KITTTITAS COUNTY COMMUNITY DEVELOPMENT SERVICES

RE: Commons at Dry Creek Planned Unit Development (PUD) PD-16-00001 and Preliminary Plat (LP-17-00004) – Transmittal of Comments Letter from Re-Notice and Request for Additional Information

SURVEYOR'S CERTIFICATE

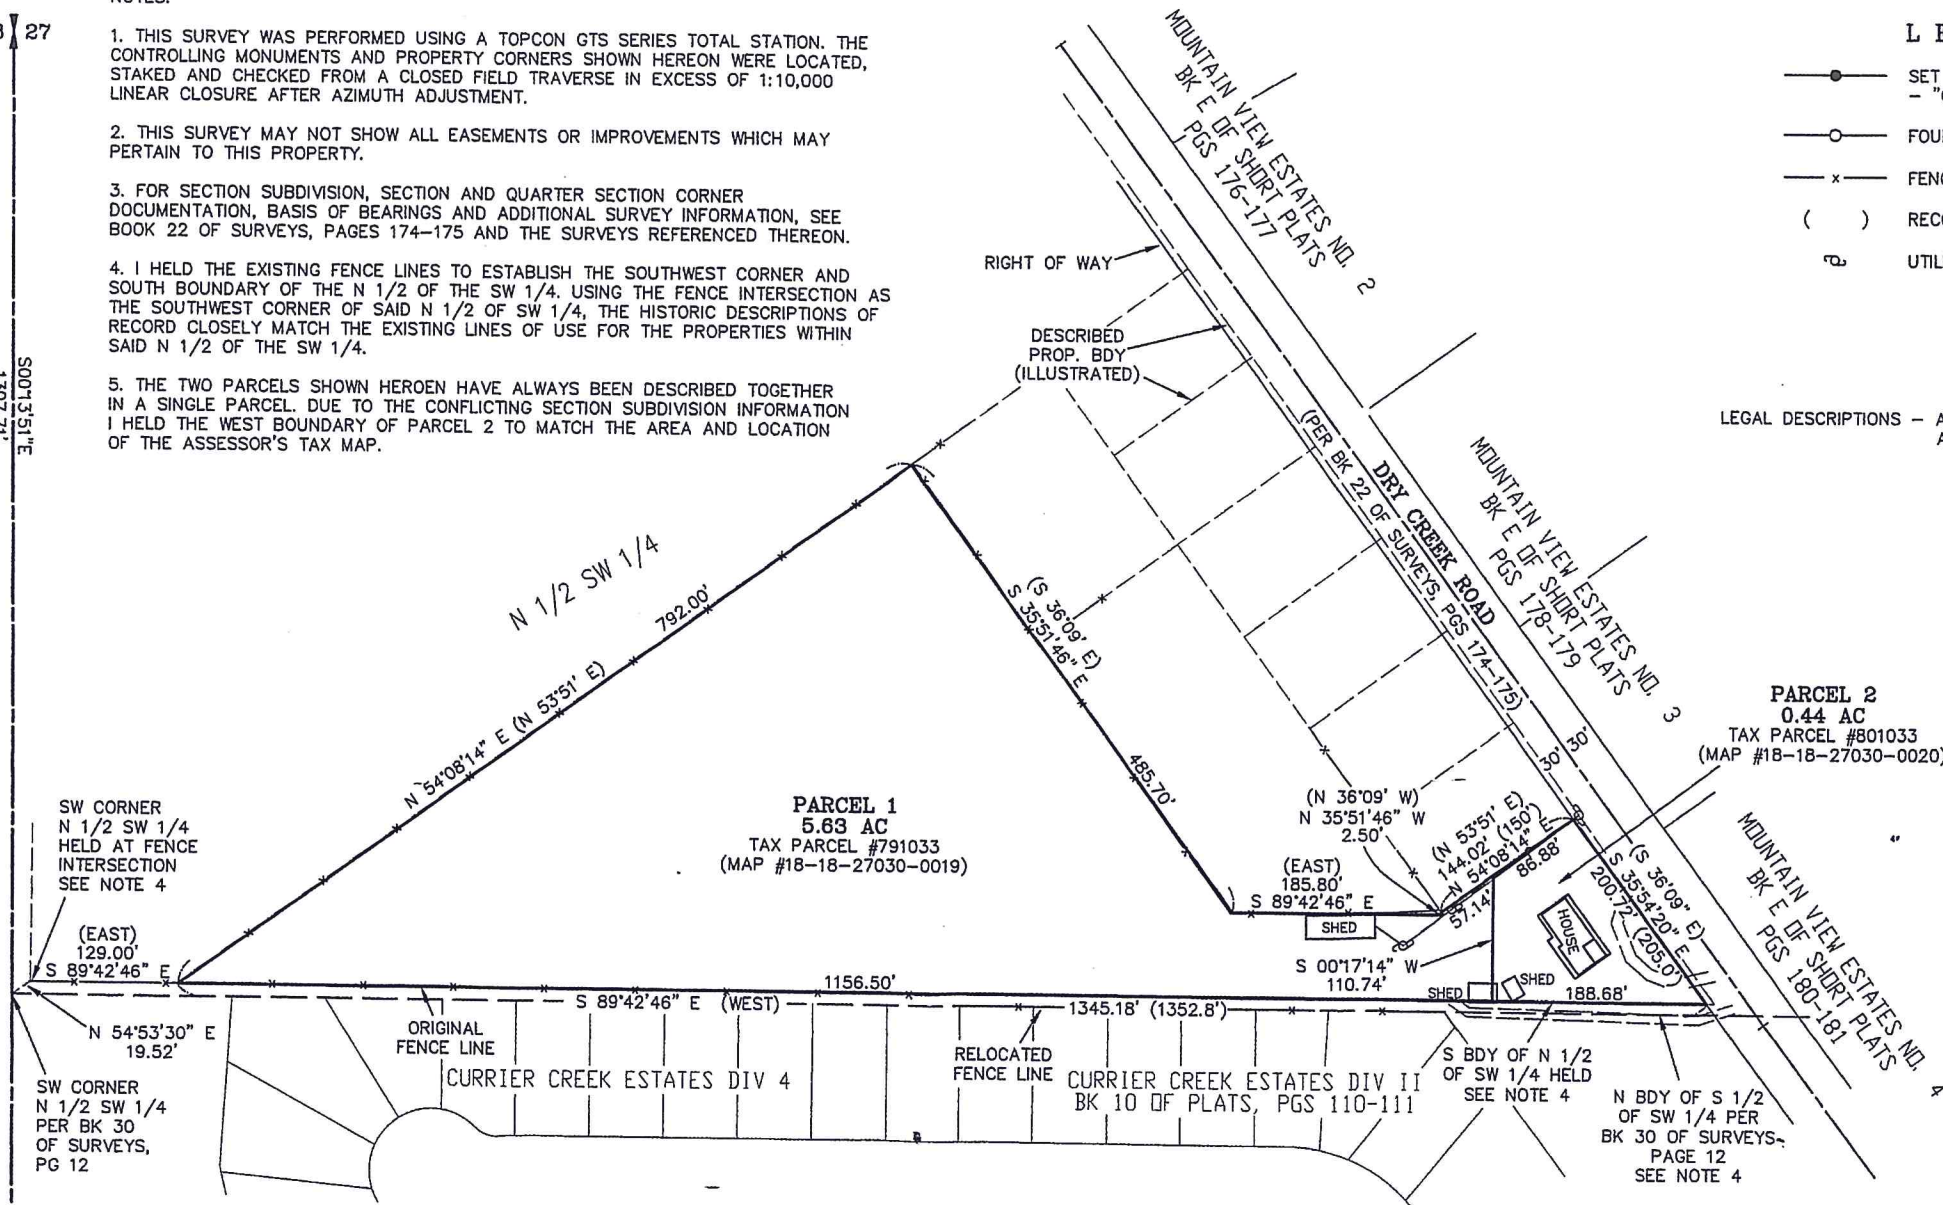
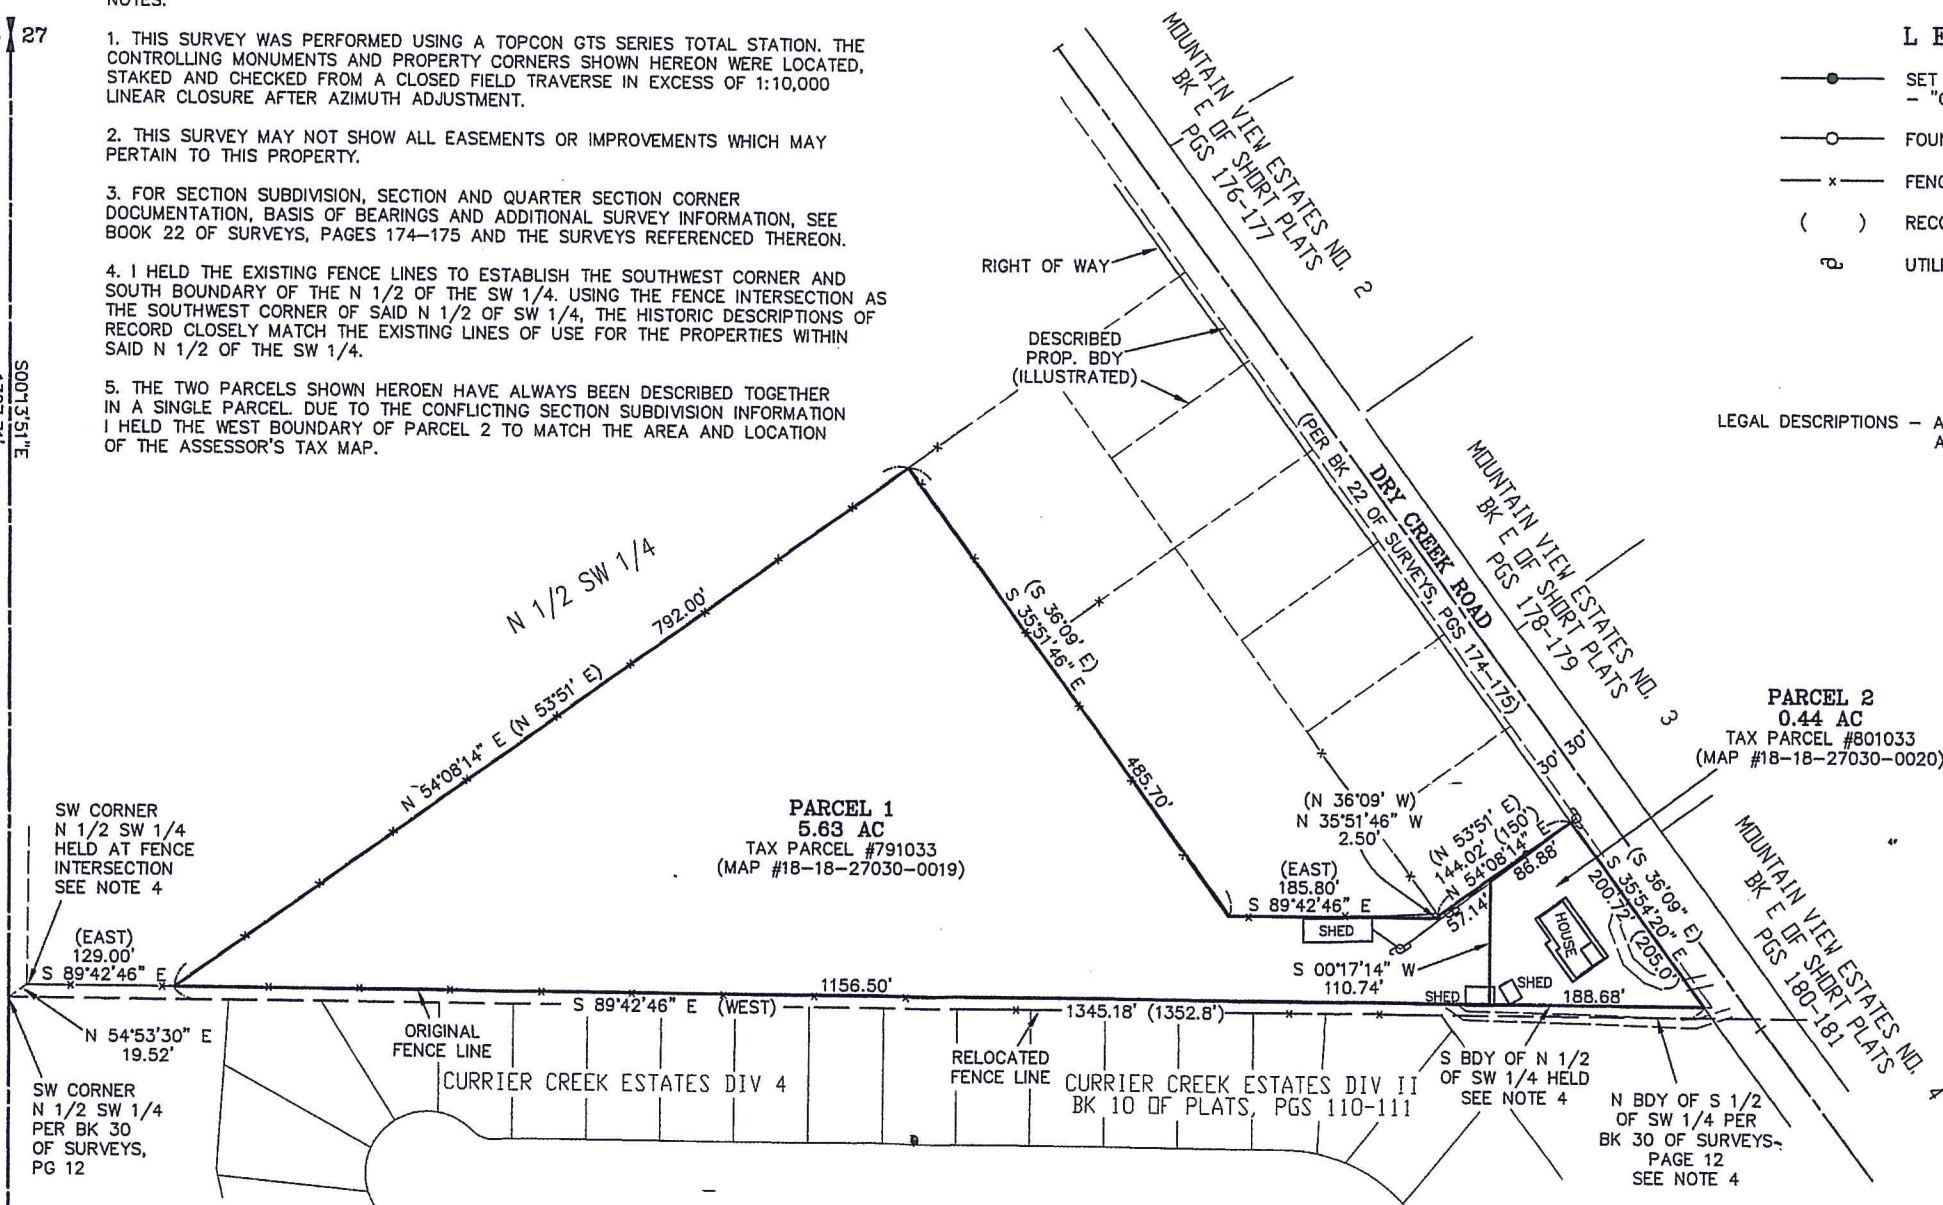
- f. The submitted preliminary survey was not signed by a licensed land surveyor, and the Surveyor’s certificate is not shown on the face of the plat.

- g. The legal description of the property to be subdivided must be included.
 - h. The vertical datum used is not noted, nor is the basis of bearings shown.

- i. A statement describing equipment and procedures used is not shown on the plat.
 - j. Buffer Setback Line is not shown in the Legend.
 - k. The access easement through the adjacent parcel must be shown on the face of the plat.

- 2) An updated stormwater drainage report depicting soil characteristics in regards to stormwater infiltration, and demonstrating that the proposal fully complies with the *Stormwater Management Manual of Eastern Washington*.
- 3) Complete a transportation concurrency application with Kittitas County Public Works. This application shall be submitted directly to Kittitas County Public Works; application is attached to this letter.
- 4) Provide the document "Infiltration Letter for Cottage Grove Residential Development, Kittitas, Washington".
- 5) An updated access easement meeting minimum side yard setbacks of 15 feet under KCC 17.22.060.
- 6) A revised preliminary survey meeting items 2(f - k) above.

EASEMENT DESCRIPTION

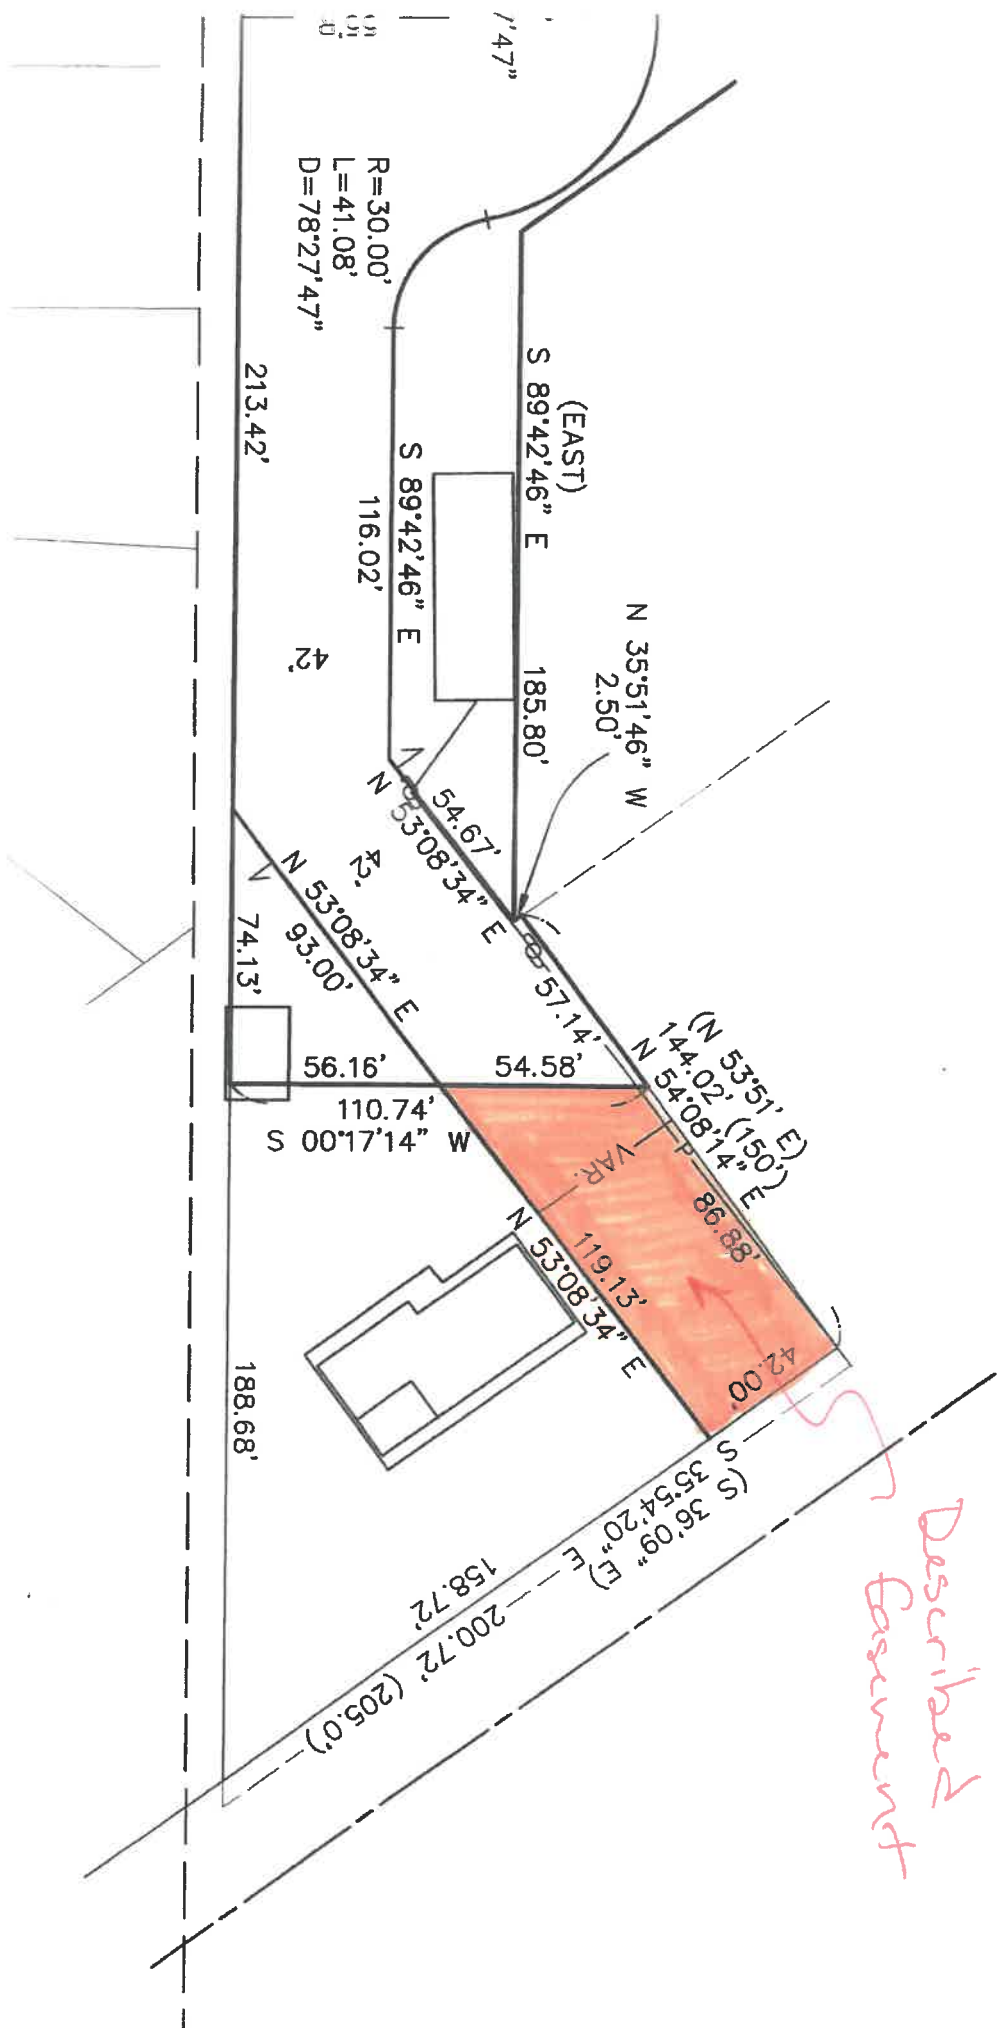
- d. Flooding has occurred proximate to the proposed development.
 - e. The current recorded access easement does not meet the required minimum side yard setback of 15 feet.

Preliminary Drainage Report

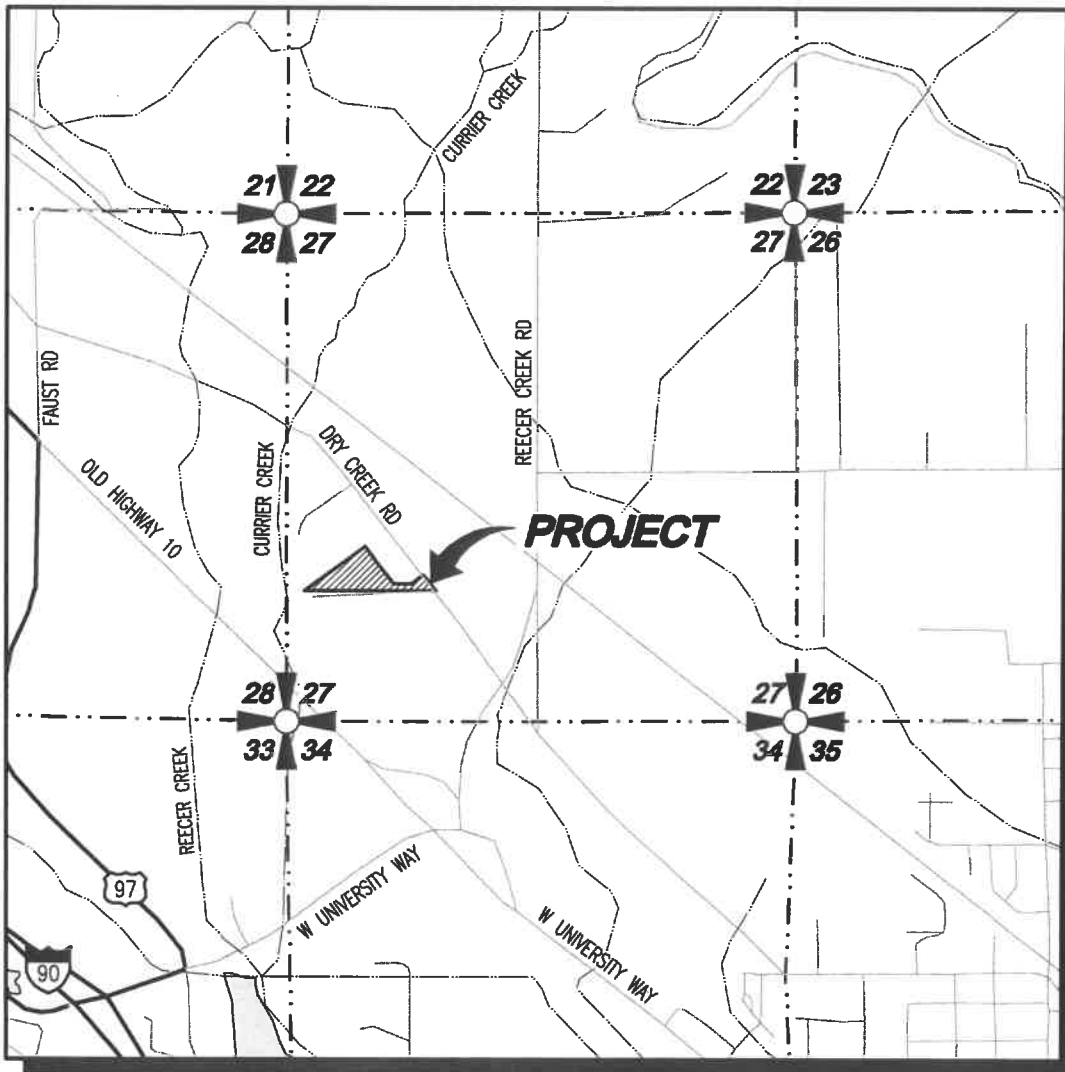
- 2) In its letter dated August 28th, 2018, Kittitas County Public Works refers to concerns regarding stormwater and potential flooding.
 - a. A stormwater drainage report was submitted, but did not adequately address the soils characteristics in regard to stormwater disposal. The report makes reference to “Infiltration Letter for Cottage Grove Residential Development, Kittitas, Washington”, but the document was not included for review.

- b. The proposal must fully comply with *The Stormwater Management Manual of Eastern Washington*. The *Manual* stipulates a 5 foot separation from infiltration strategies to a seasonal high water table.
